2 storey rear extension & pitched roof to existing garage
Downfields Level Mare Lane Eastergate PO20 3SB

Please ask for:
Mrs S Honney-Bayes
01903 737500 Ext 37445
17th February 2012

**2 storey rear extension & pitched roof to existing garage
Downfields Level Mare Lane Eastergate**

PROPOSED SOUTH ELEVATION 1-100
PROPOSED ELEVATIONS

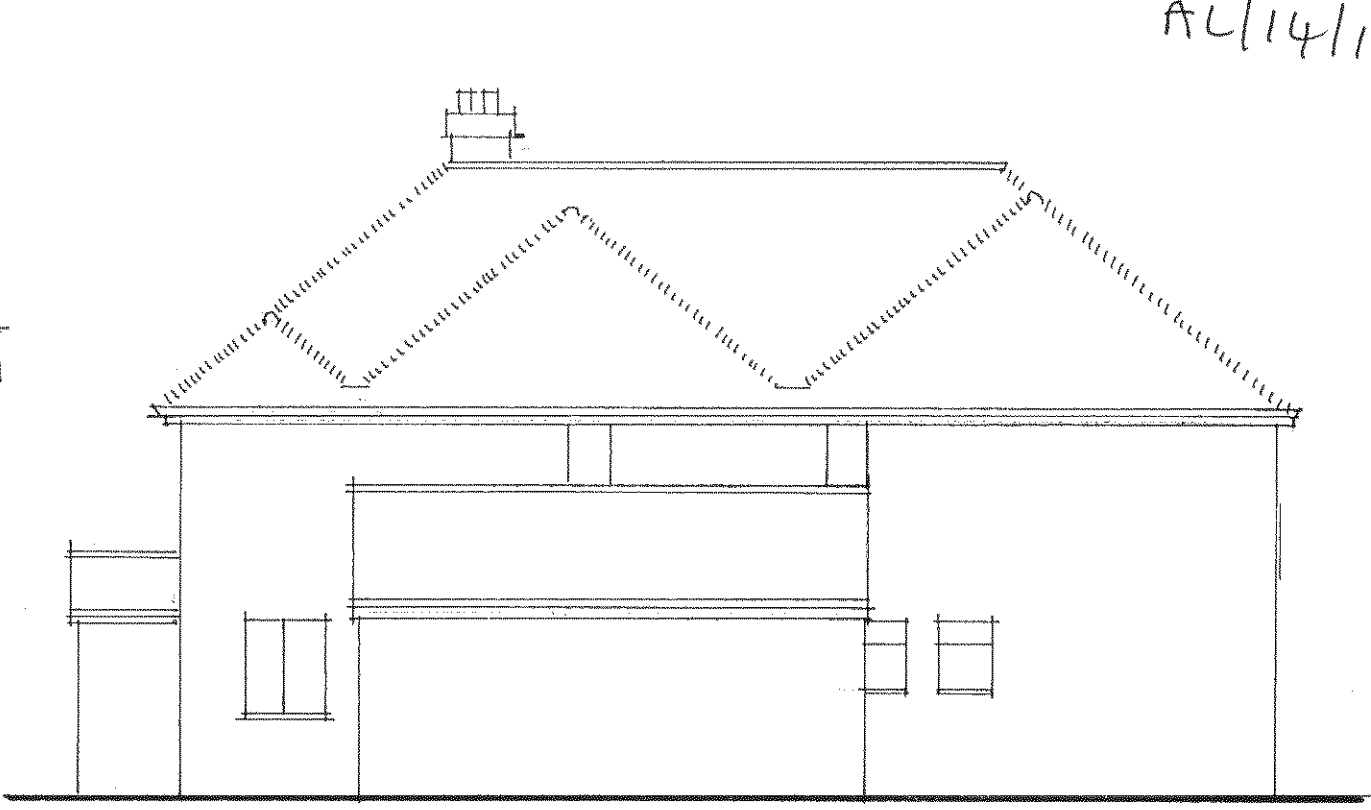
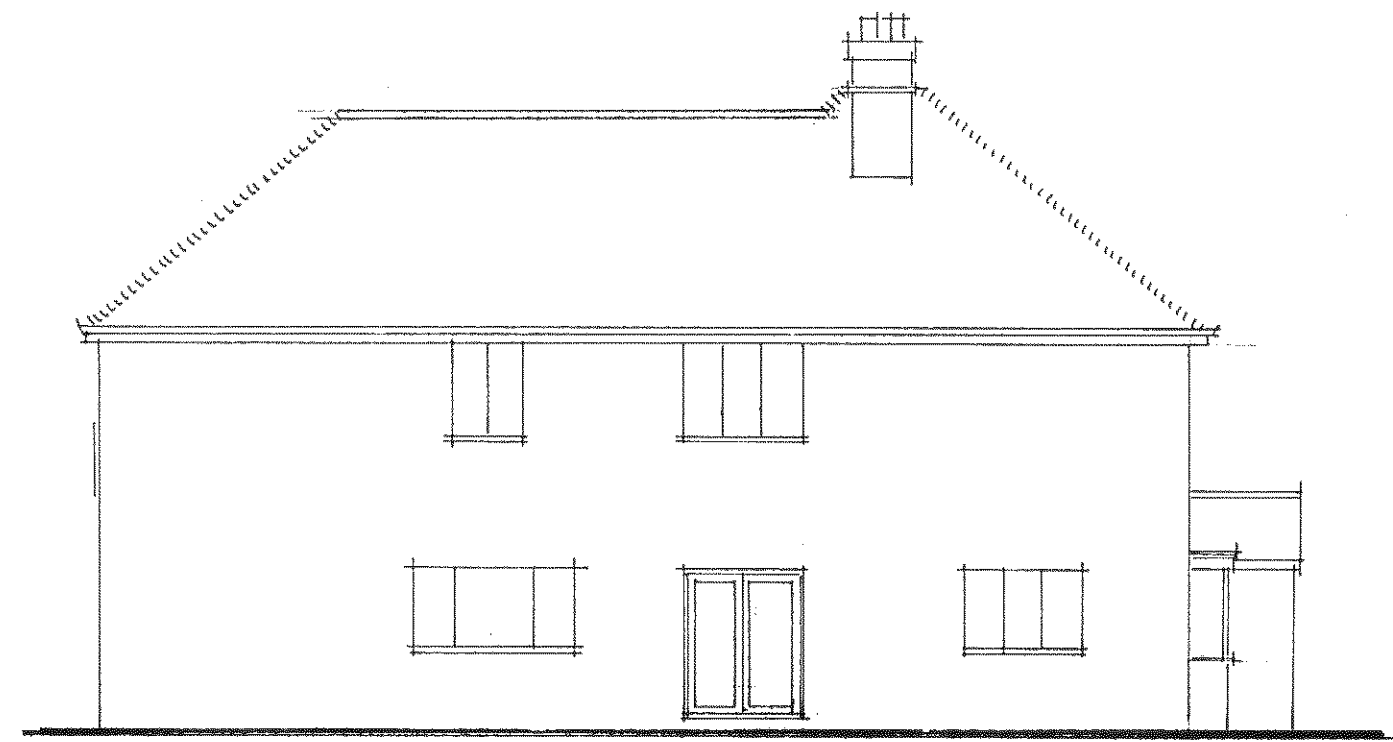
Please provide 1 electronic or 3 paper copies of revised proposed north and south elevations to show the juliet balcony. ✓

Please provide 1 electronic or 3 paper copies of existing and proposed south elevations of the garage. ✓

EXISTING GROUND FLOOR PLAN 1-100

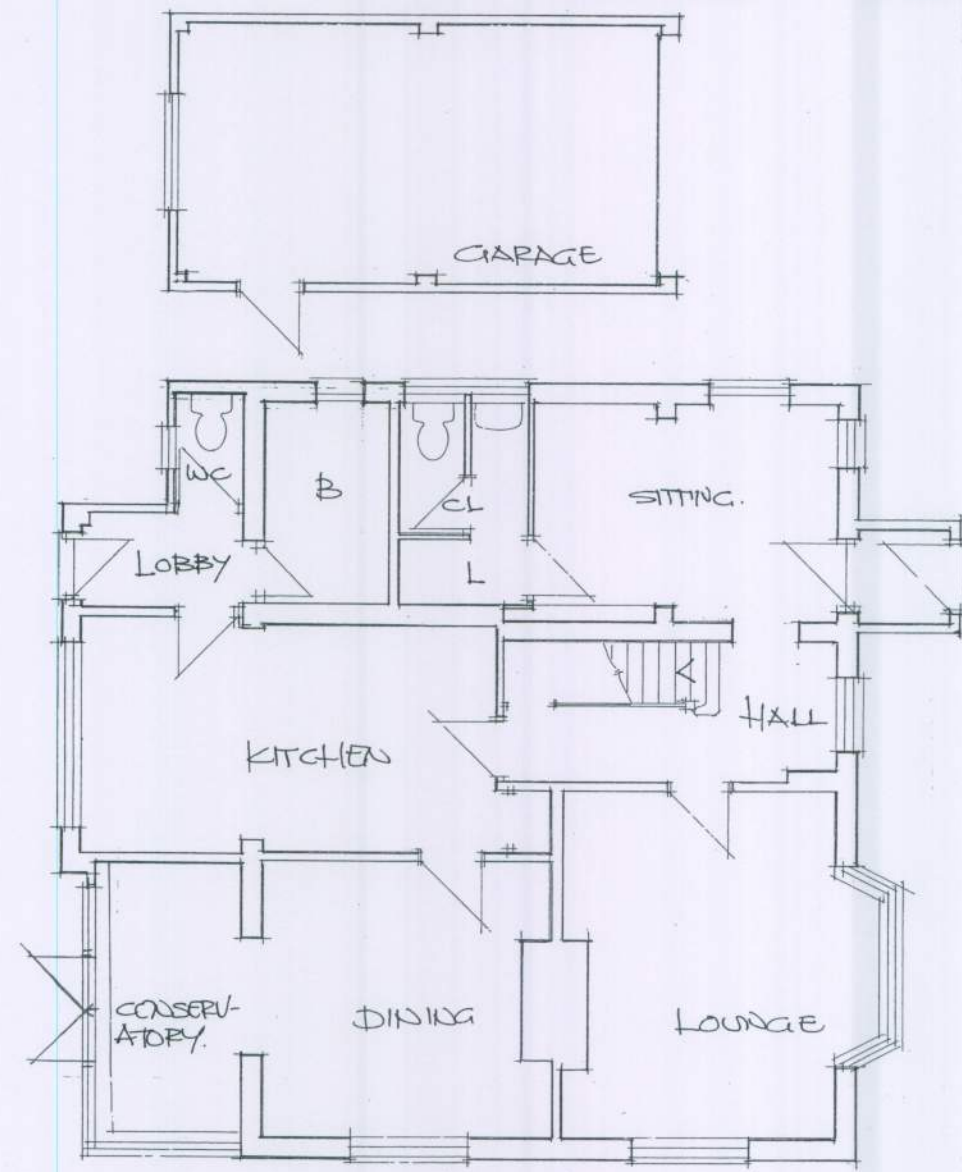
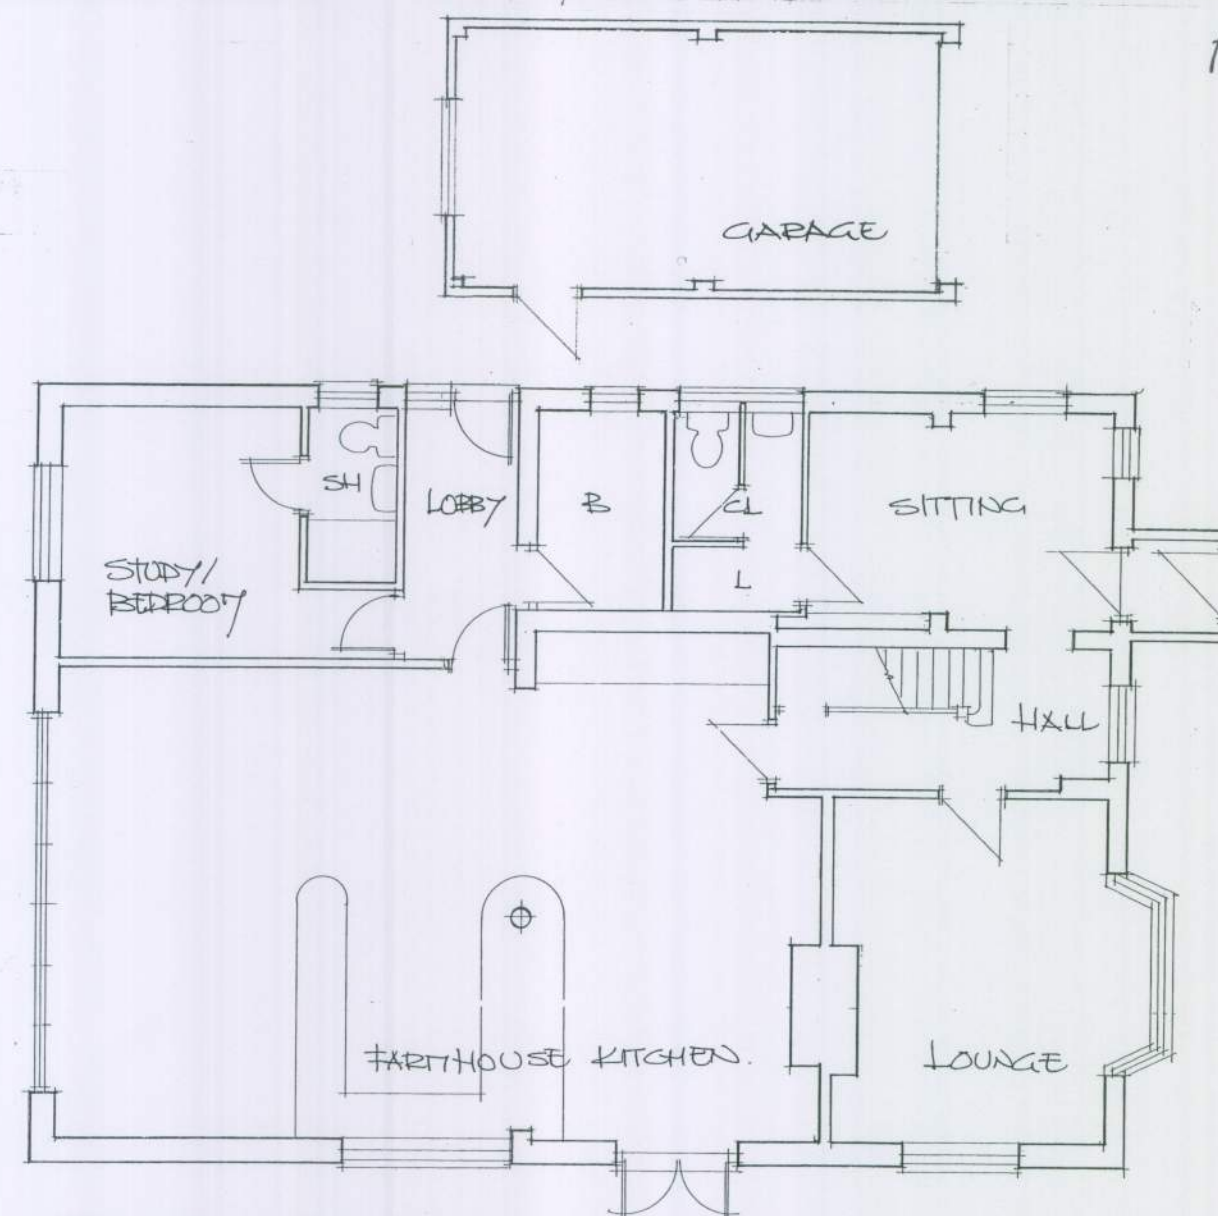
Please provide 1 electronic or 3 paper copies of a revised existing ground floor plan to show the conservatory doors. ✓
